CITY OF PORTLAND BUILDING PERMIT

This is to certify that **CHRISTOPHER A. MOONEY** Located At **27 SUNSET AVE**

Job ID: 2011-03-630-SF

has permission to Amend; enlarge deck 2'

**BOUNDARY SURVEY OF LAND ON
SUNSET AVENUE AND CLEEVE STREET,
GREAT DIAMOND ISLAND, PORTLAND, MAINE**

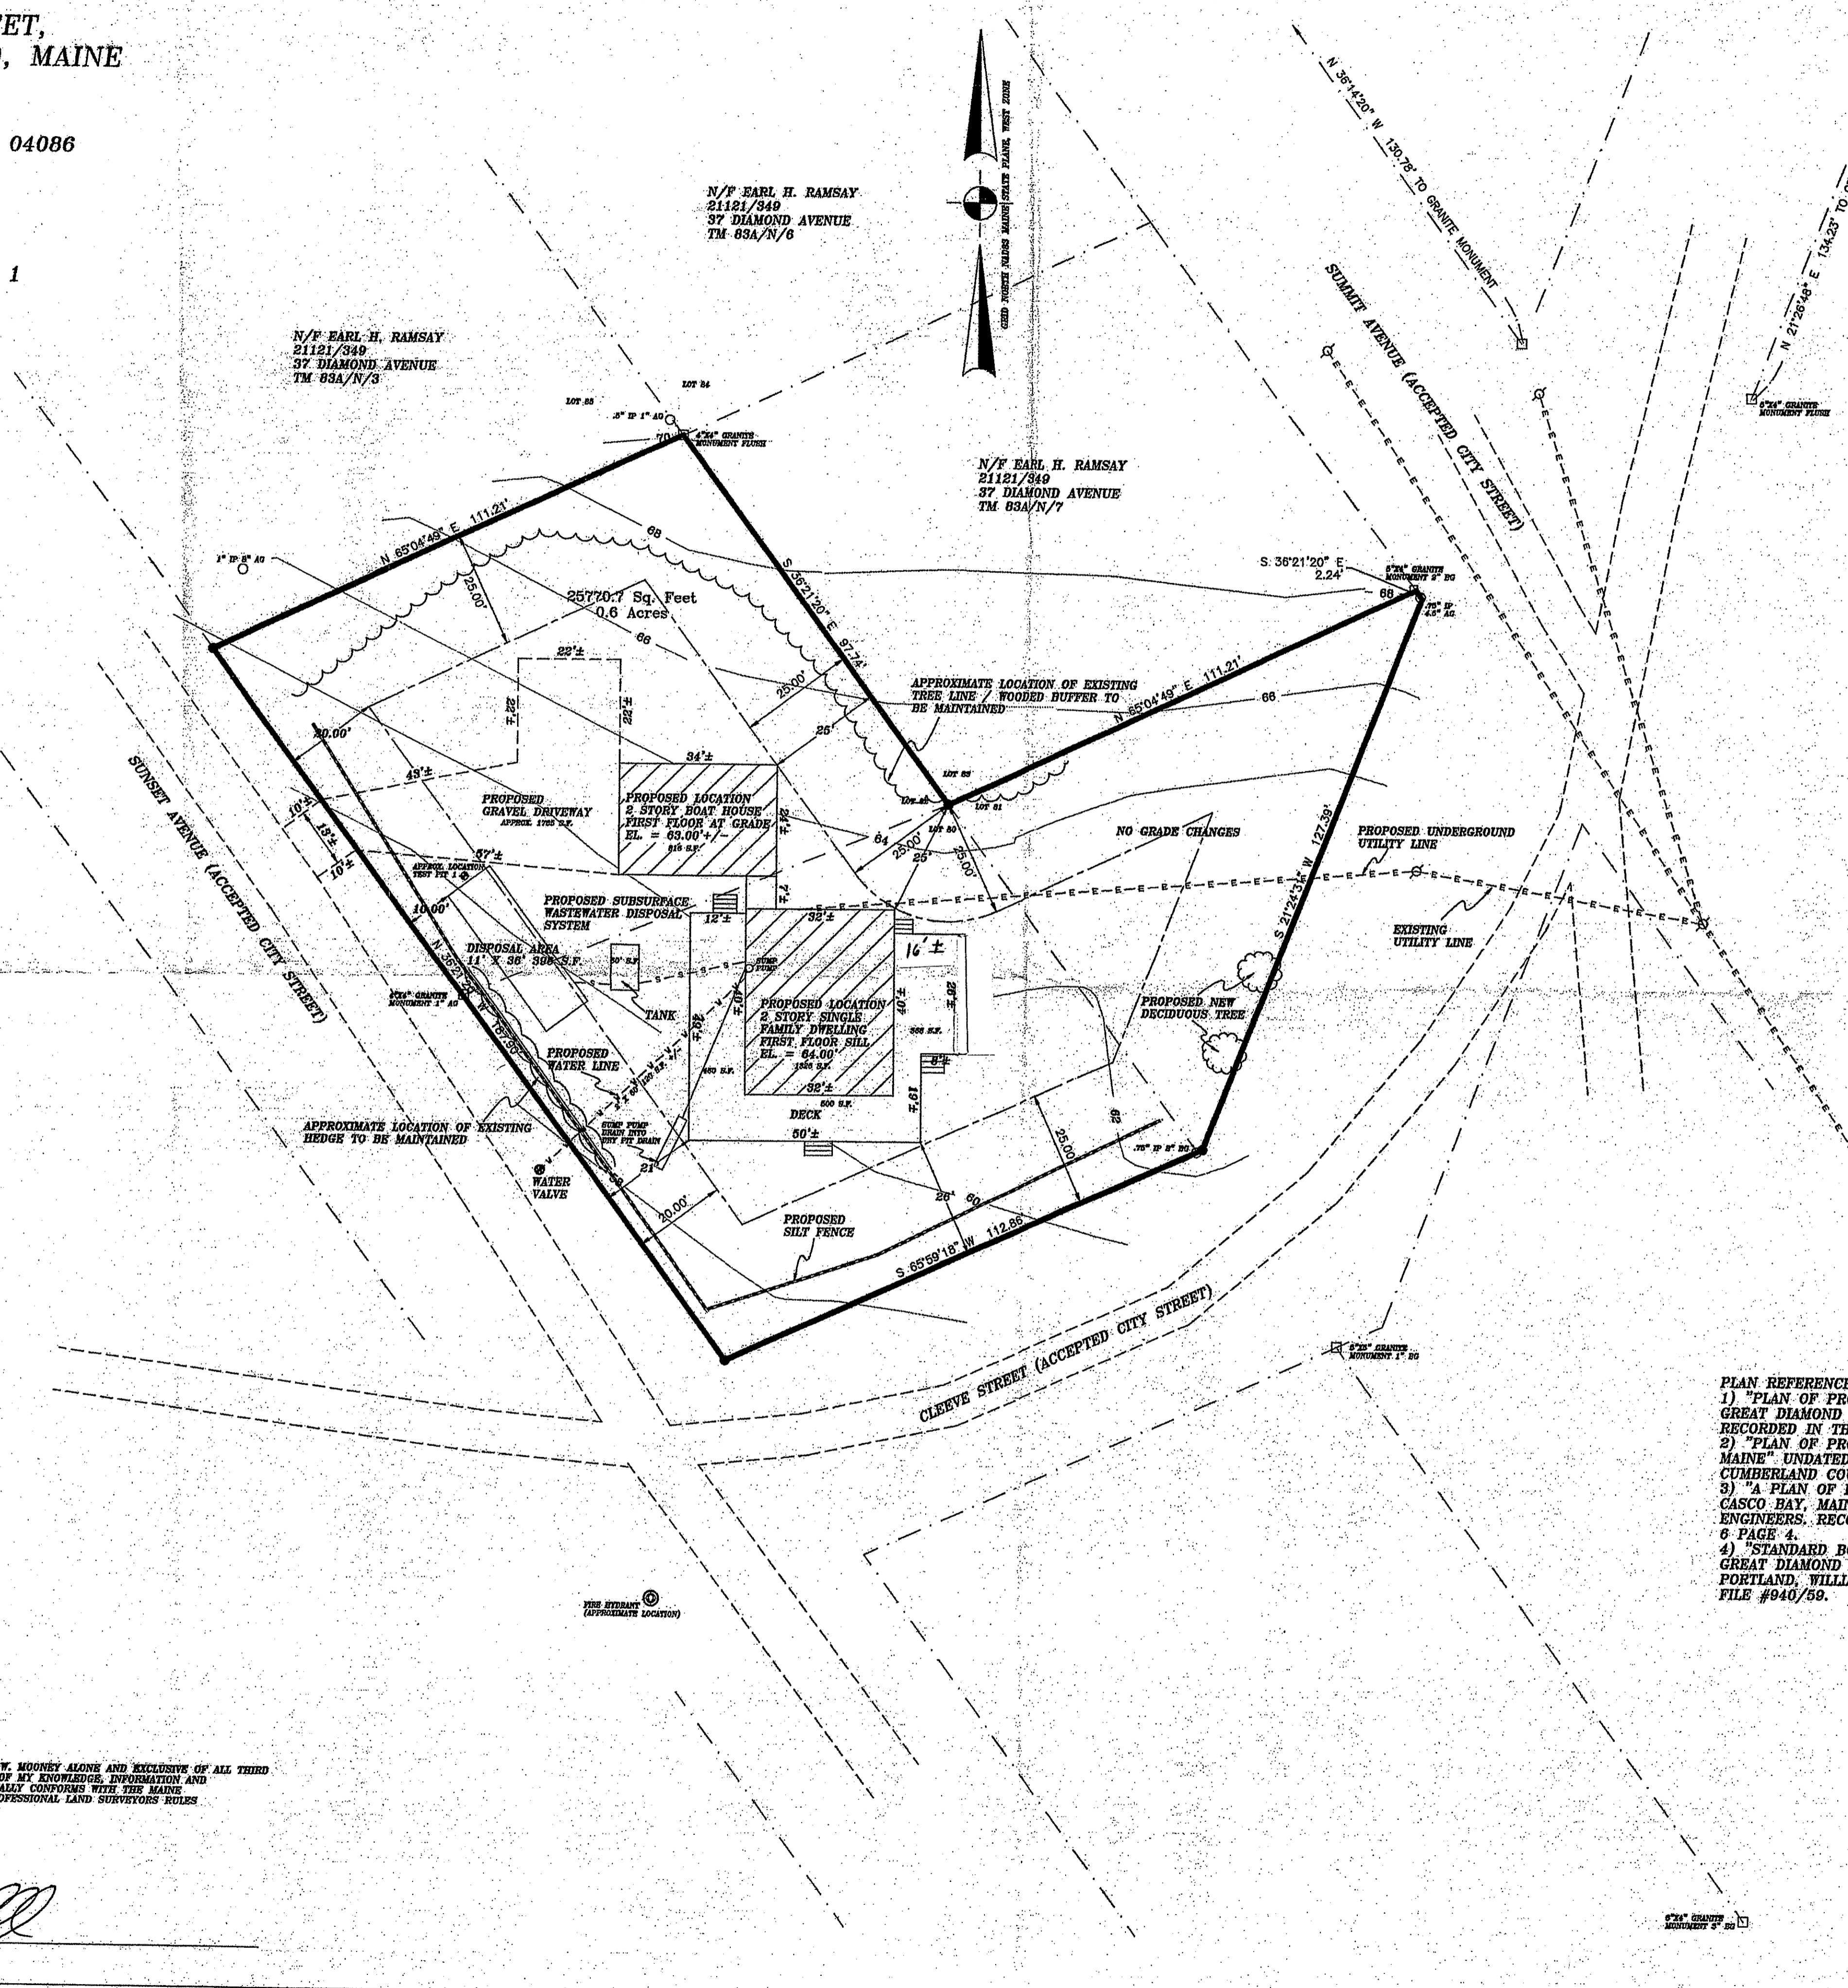
Proposed Use/Work - build new 2 story single family home (32'x40') w/ 3 sided wrap ground deck & attached 24'x34' bathroom. * expand deck on right side 2'
